Our Reference: SYD17/01651\_2 & SYD17/01653\_2  
Your Ref: SSD8925 & SSD8925

**PROPOSED NEW SYDNEY FISH MARKET  
STAGE 1 CONCEPT WORKS AND STAGE 2 MAIN WORKS  
1A TO 1C BRIDGE RD, GLEBE & PART 56-60 PYRMONT BRIDGE ROAD, PYRMONT**

Roads and Maritime has reviewed the submitted application does not provide concurrence for the proposed development application. The following additional information shall be provided:

THIS DRAWING MAY BE PREPARED IN COLOUR AND MAY BE INCOMPLETE IF COPIED
0 5 10 15 20 25 30 35 40 45 50mm ON A3 SIZE ORIGINAL

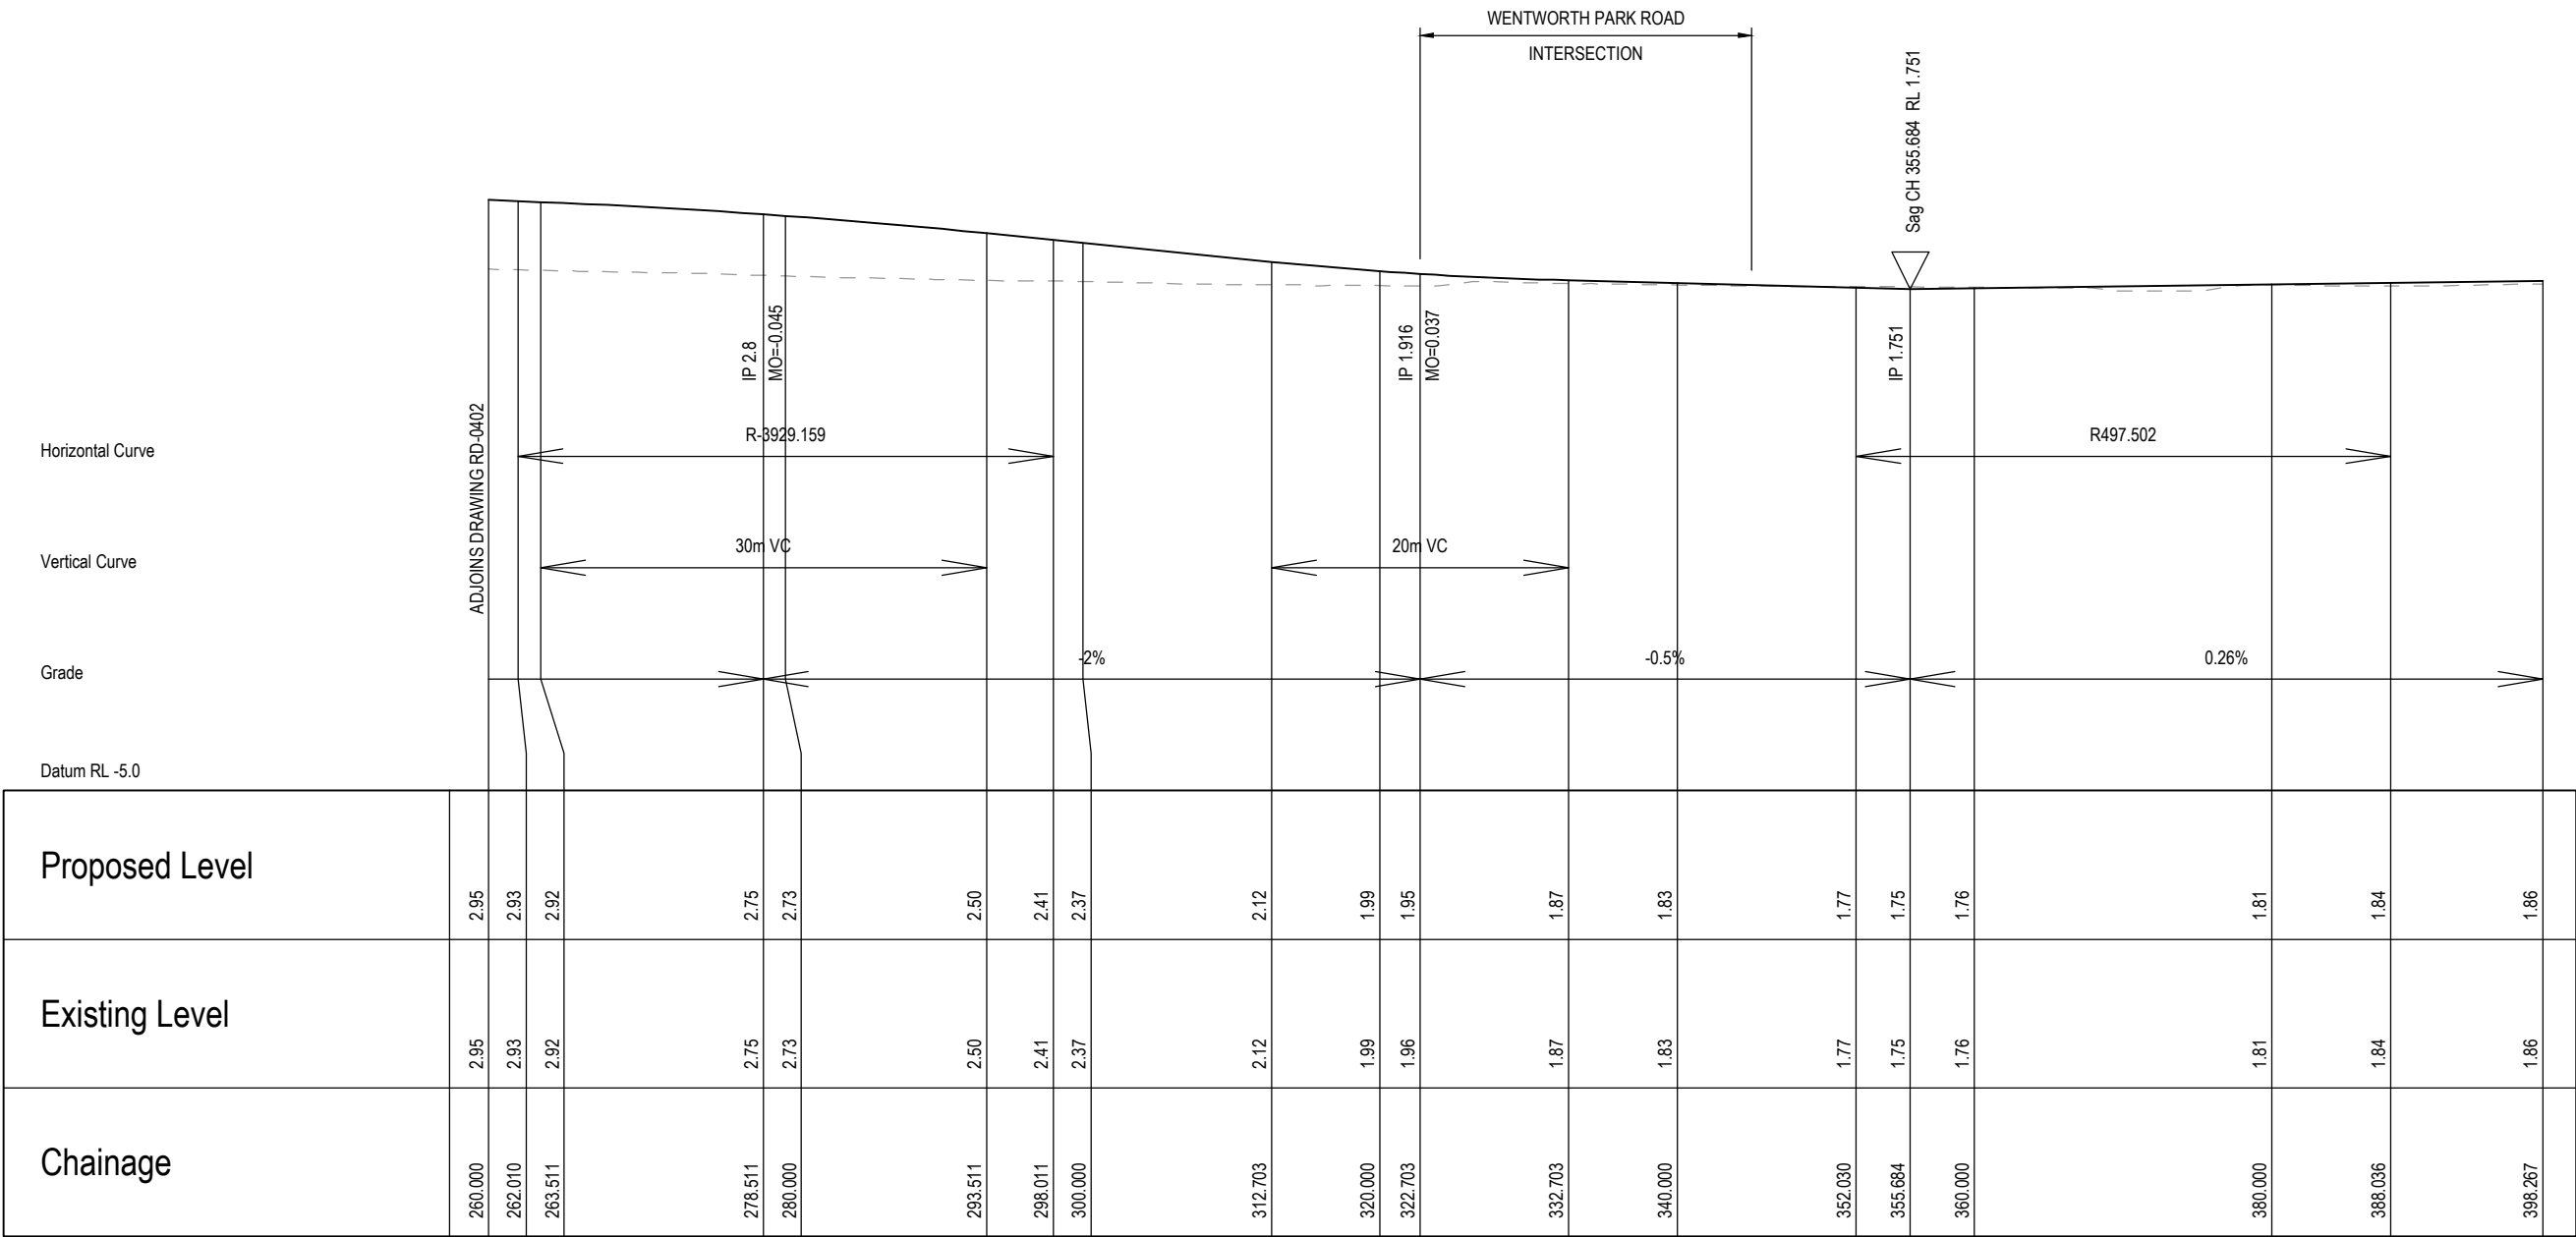
10. The proposed increase in road level along Bridge Road between Wattle Street and Wentworth Park Road will require removal of a significant amount of foliage from the established Moreton Bay fig trees. These are considered to be highly important to the community and should be protected where possible. Furthermore the increase in finished levels along Bridge Road will potentially exacerbate localised flooding on the surrounding road network.
